**KIRKLEES METROPOLITAN COUNCIL
INVESTMENT & REGENERATION SERVICE**

DELEGATED DECISION TO DETERMINE PLANNING APPLICATIONS

Reference No:	2024/62/91044/W
Site Address:	35, Cumberland Avenue, Fixby, Huddersfield, HD2 2JJ
Description:	Erection of extensions including associated alterations
Recommending Officer:	Molly Storer

Officer Report

1 Second Floor Plan
Scale: 1:50

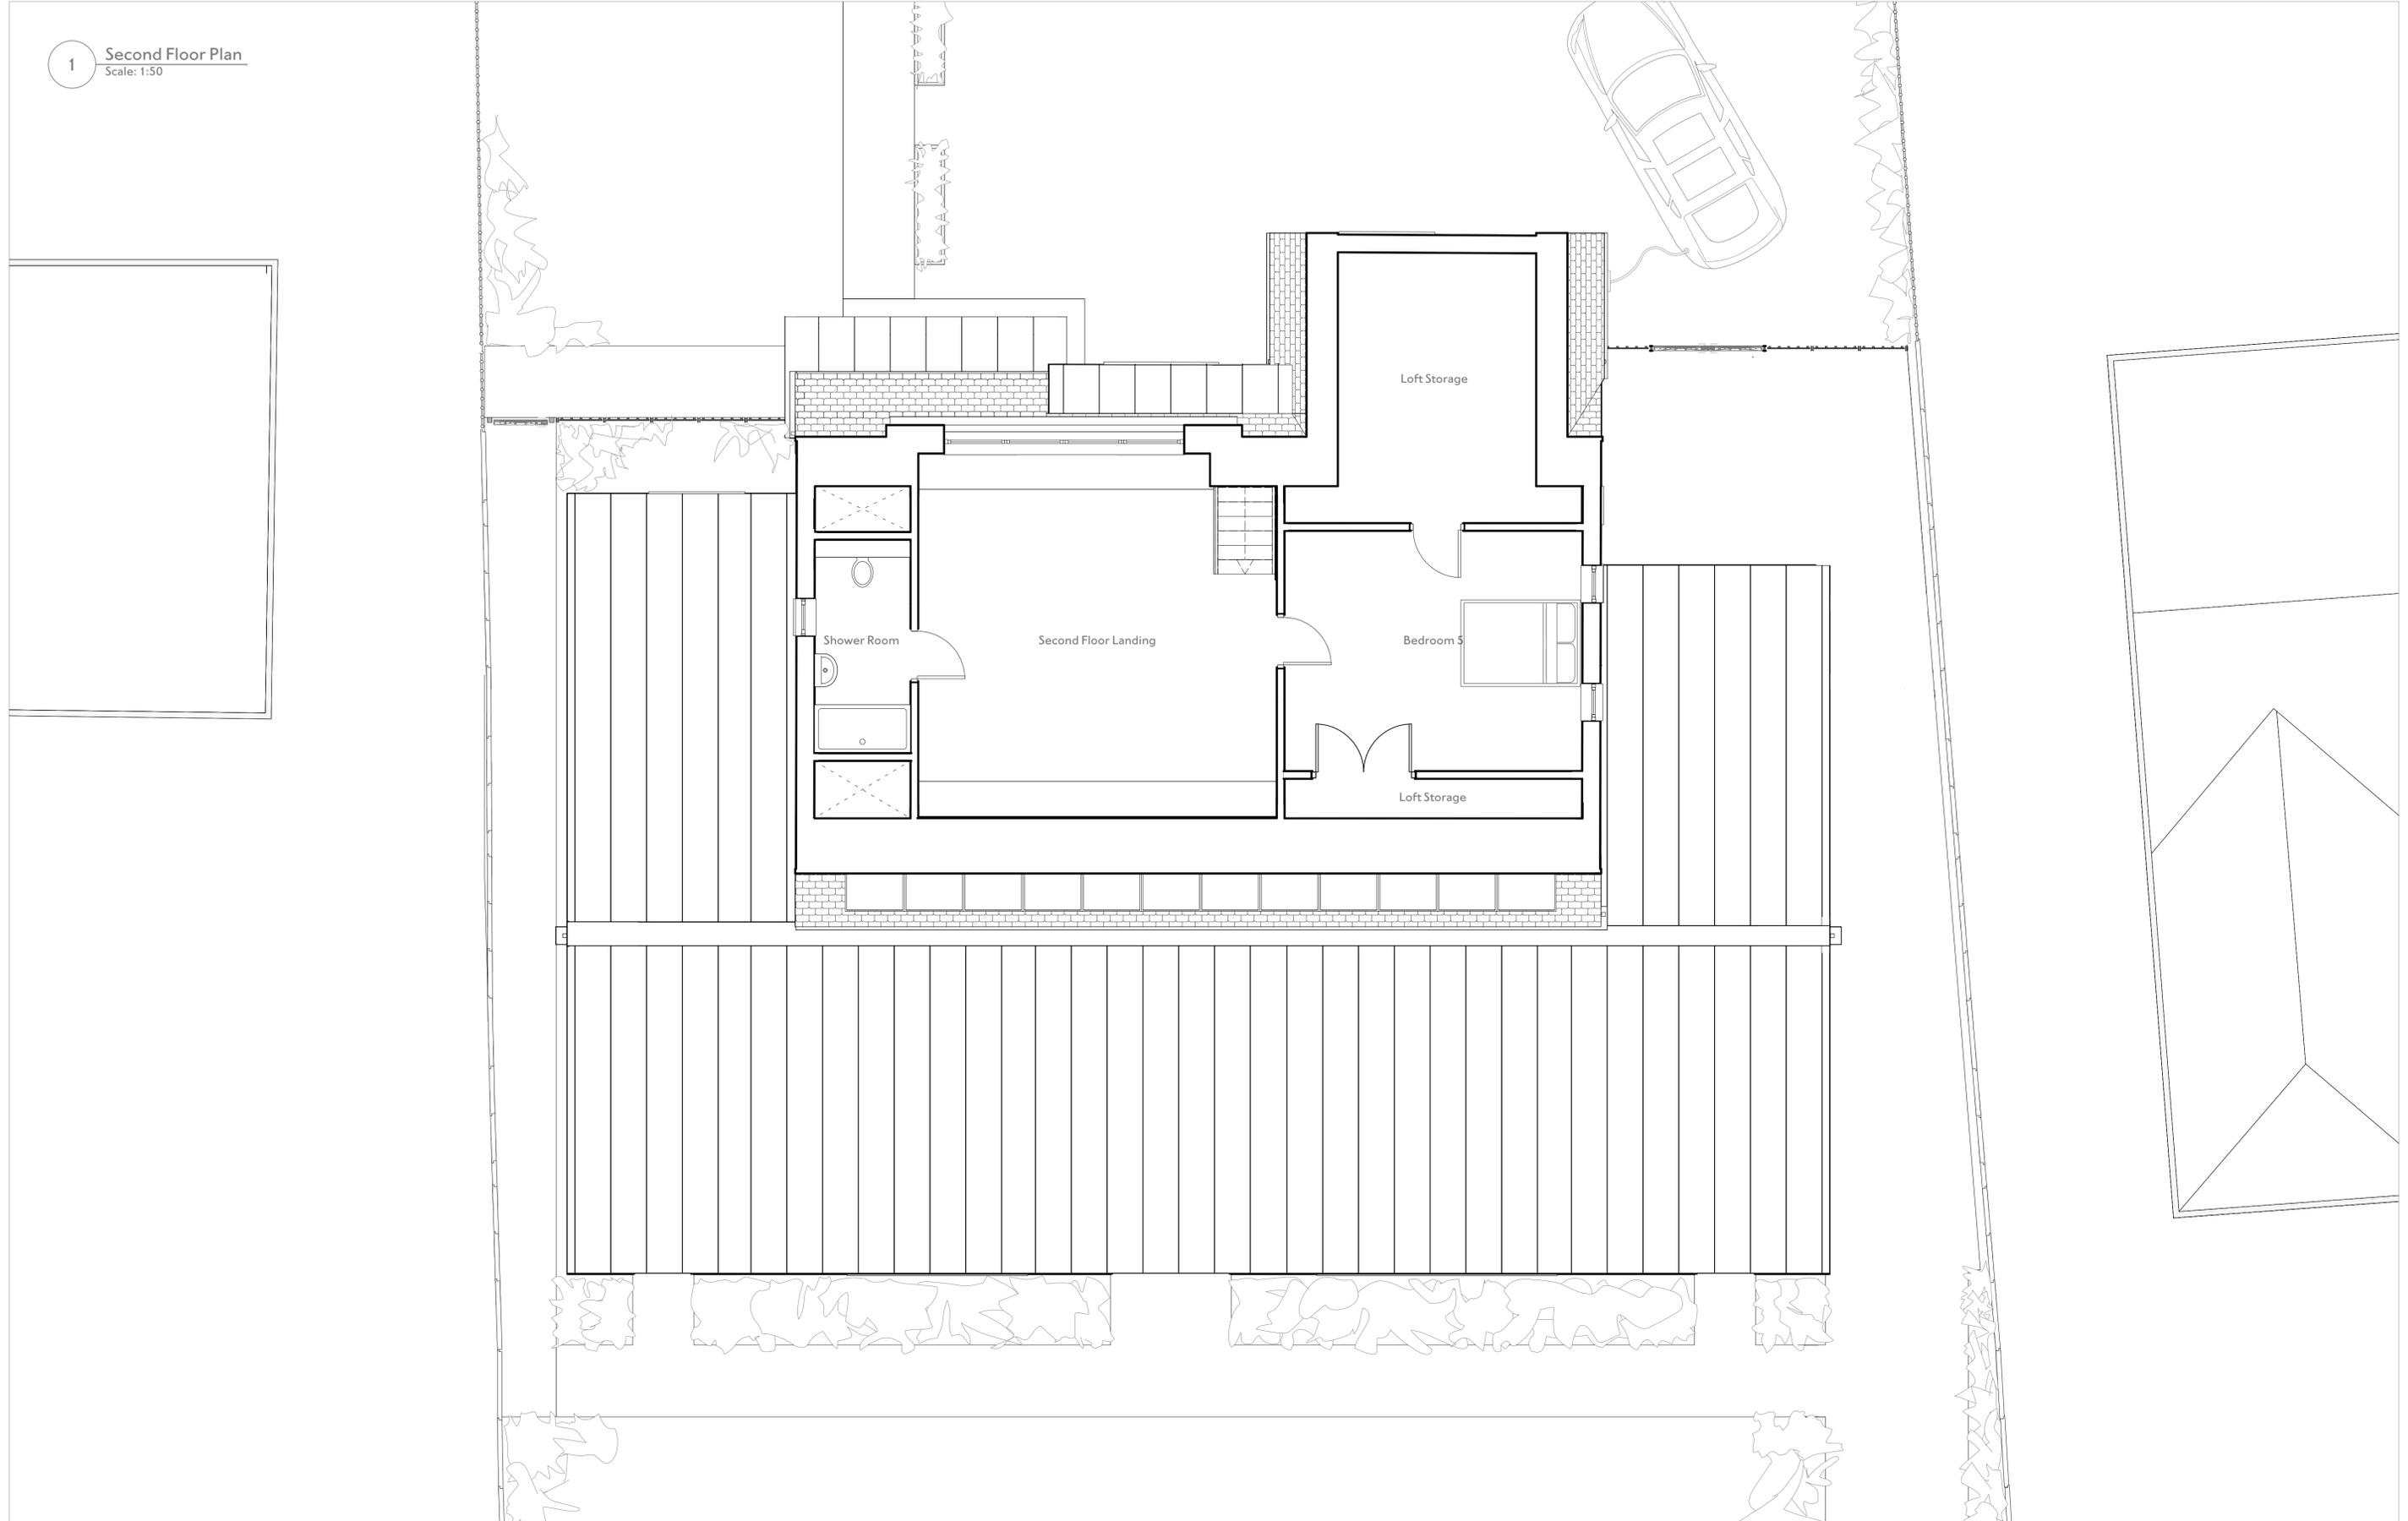
- Flat roof elements to the front elevation should be removed from the plans including the flat roof dormer and the two storey element, due to these being out of character of the area.
- The roofs of the side extensions should be in keeping with the roof pitch of the main dwelling rather than a flat roof design.
- Consideration should be given to reducing the projection of the rear extension.

Original plans showed that the roof design of the front/side elevations would be a flat roof it was suggested that this would be out of character with the area. Original plans also showed a flat roof dormer which was also considered not to be in keeping with the area. The design was amended to remove the front dormer and changed to be pitched roofs throughout. In doing so the the overall height of both the main roof and the front principal gable has been reduced.

1 East Elevation - proposed
Scale: 1:50

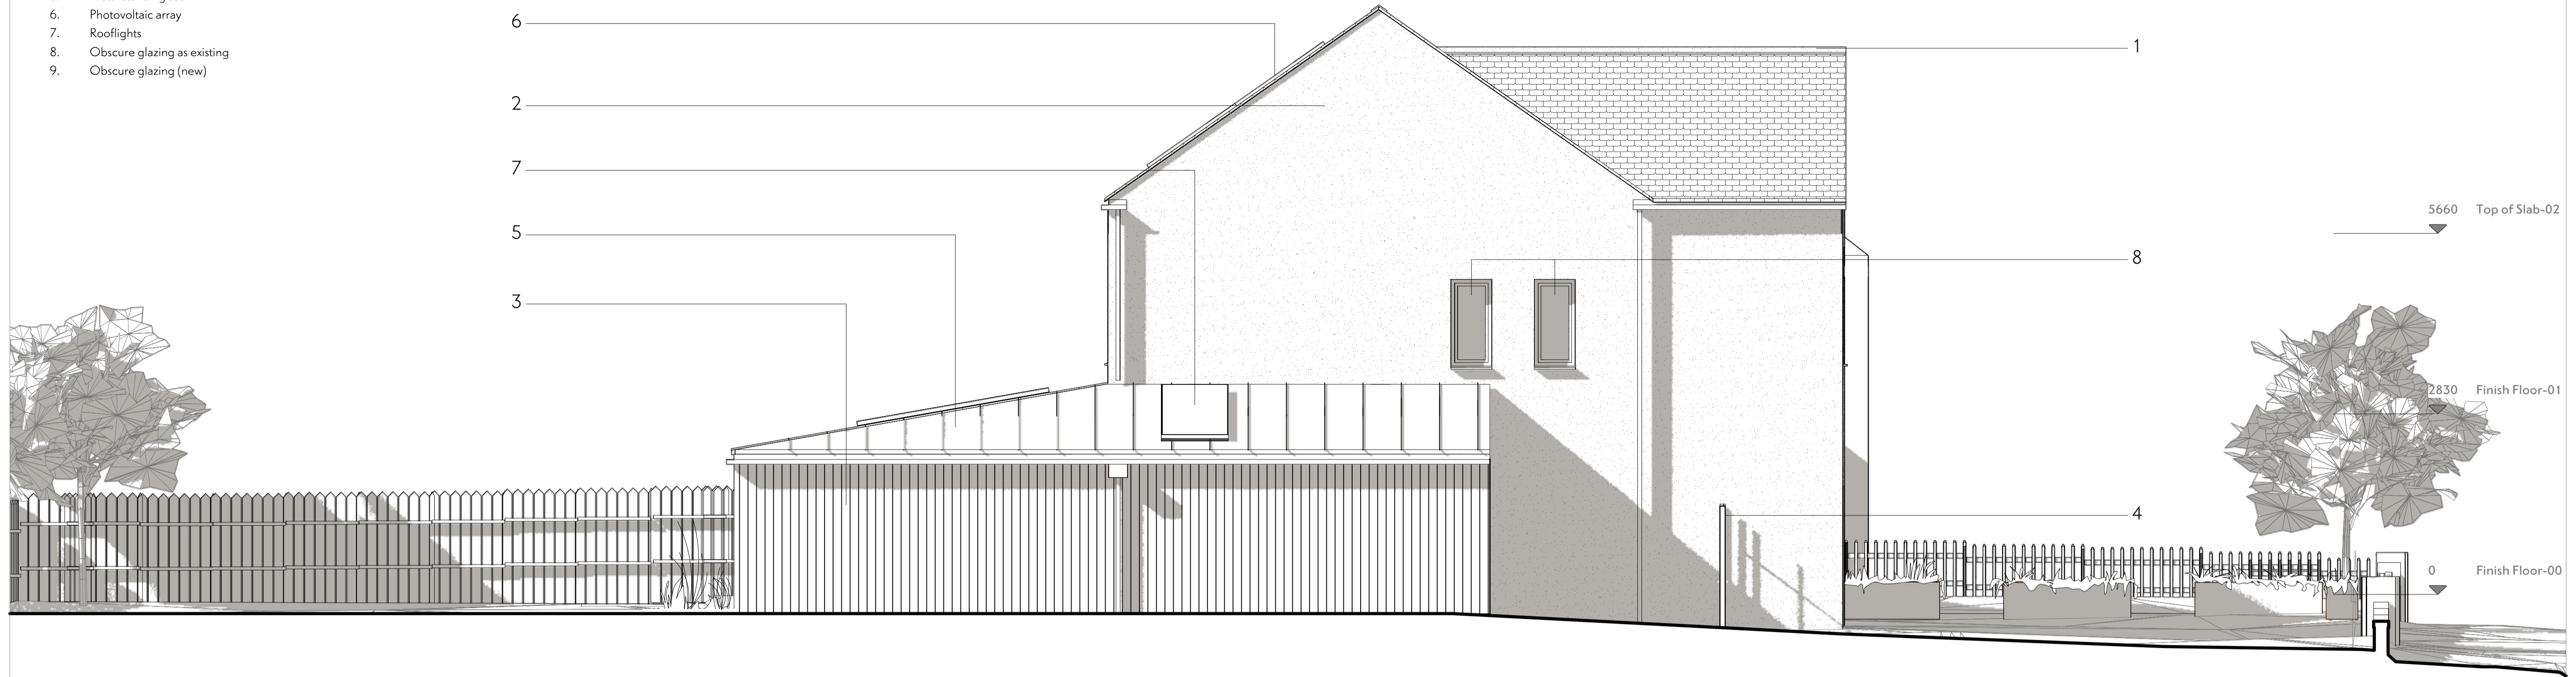
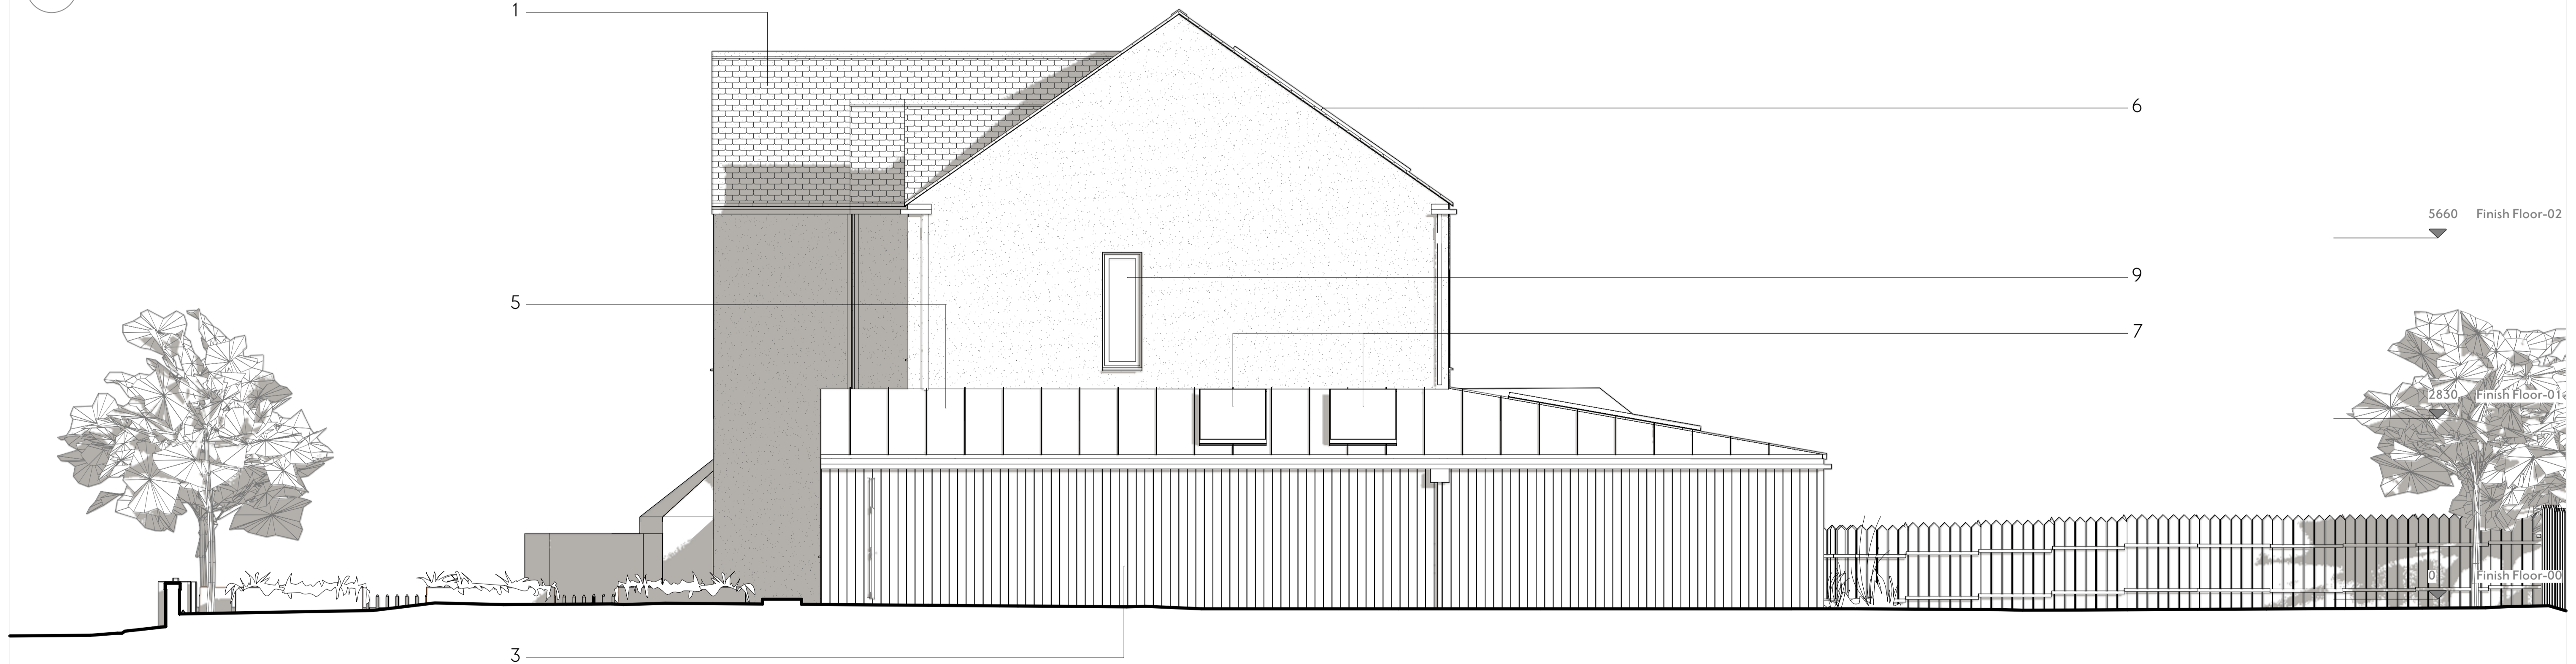
Furthermore, the revised scheme was amended to a low profile pitched roof wrapping around the original house and sloping away from the house, therefore forming two monopitch gables to the street elevation. Due to this amendment the lowered internal height of the extension it will be less visible from the street and will appear subservient to the original house.
